**Response to Planning application from Hertfordshire County Council (T and CP GDP Order 2015)**

District ref: 6/2021/2260/FULL  
HCC ref: WH/8633/2021  
HCC received: 20 October 2021  
Area manager: Matthew Armstrong  
Case officer: Samuel Tearle

SHELL WELWYN GARDEN CITY STANBOROUGH ROAD WELWYN GARDEN CITY AL8 6XA

Redevelopment of petrol station; including demolition of existing sales building, canopy link and car wash/jet washes, erection of a new sales building, provision of car parking spaces, provision of EV charging bays and associated plant, erection of a new bin store, retention of forecourt and canopy, and associated works

1:200	24.9.21	TJP	NH	TJP
2109-023		PD001		-

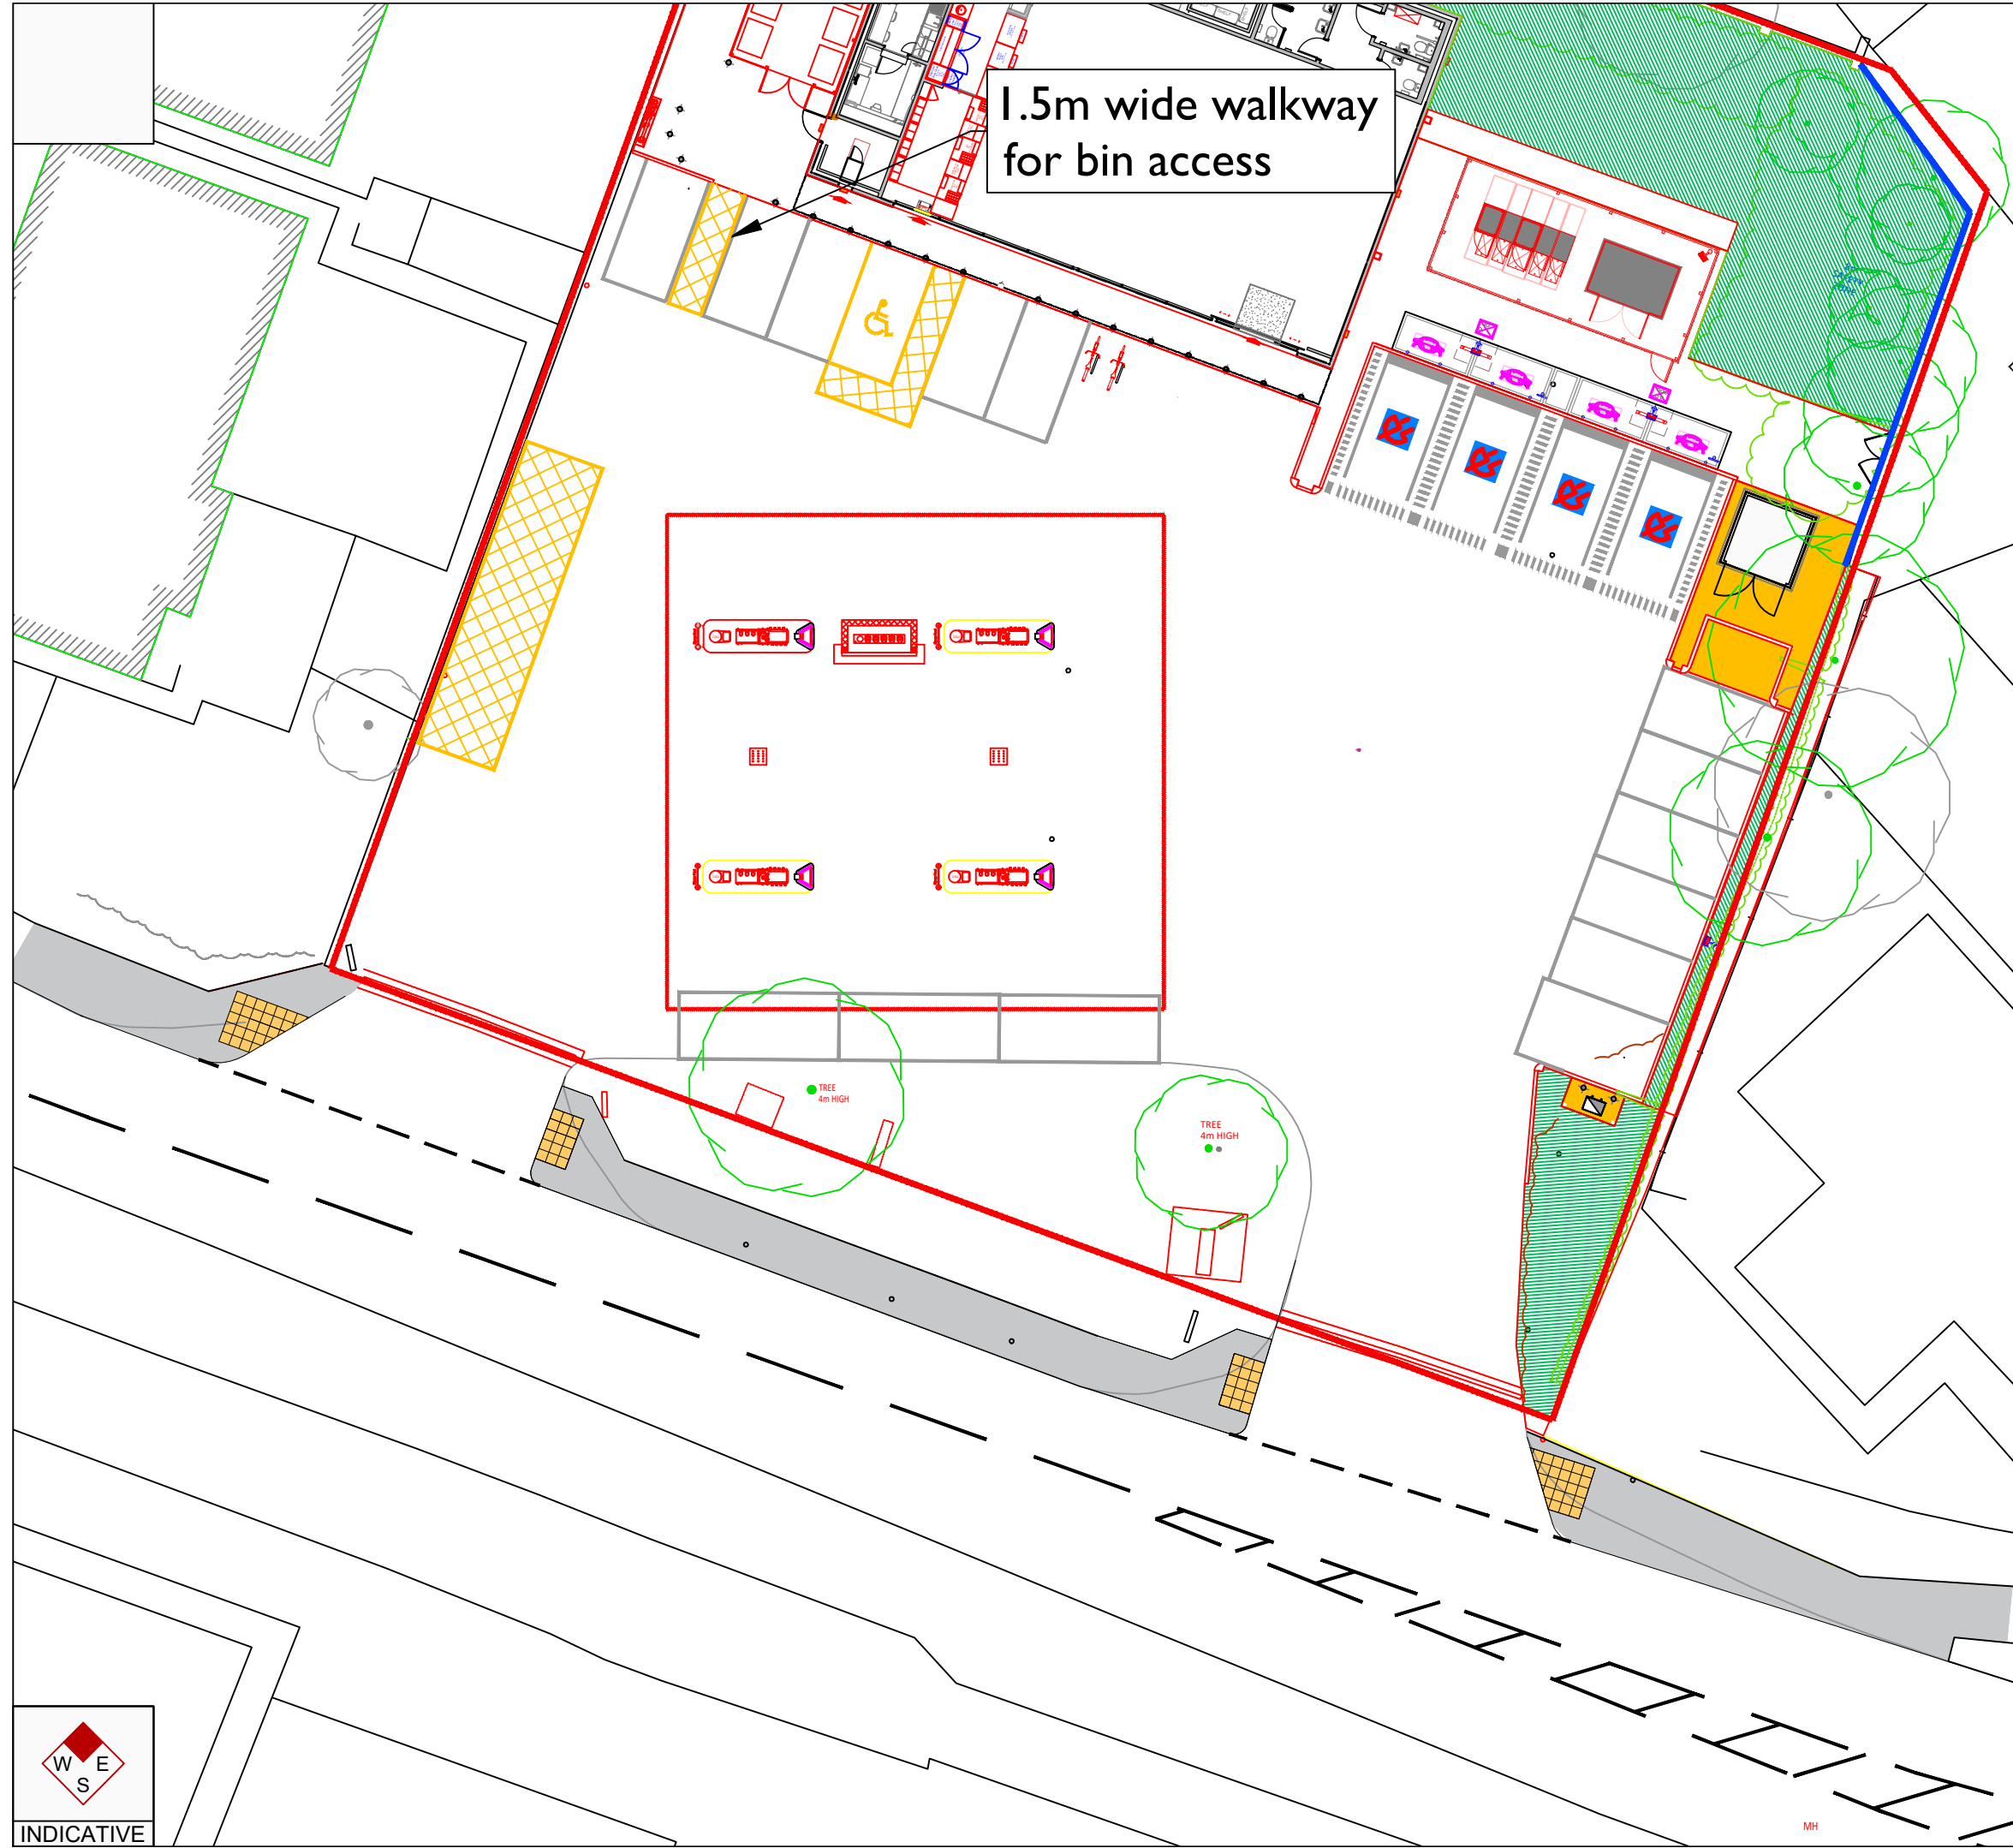
Notwithstanding the details indicated on the submitted drawings, no on-site works above slab level shall commence until a detailed scheme for the off-site highway improvement works as indicated on drawing number PD001 have been submitted to and approved in writing by the Local Planning Authority in consultation with the Highway Authority.

The updated access arrangement, as shown on Drawing No. PD001 includes the narrowing of the access and provision of dropped kerbs and tactile pavings at both of the site access. The Drawing No SP01 demonstrates a max UK legal length vehicles (16.5m) can suitably enter and exit the site in a forward gear following the proposed access works. The Highway Authority are satisfied with this proposed design as it is in line with Policies 1 & 5 of the HCC Local Transport Plan and principles of the NPPF.

The proposals also include a widened access corridor for the dragging of bins between the bin storage area and likely position of a refuse vehicle.
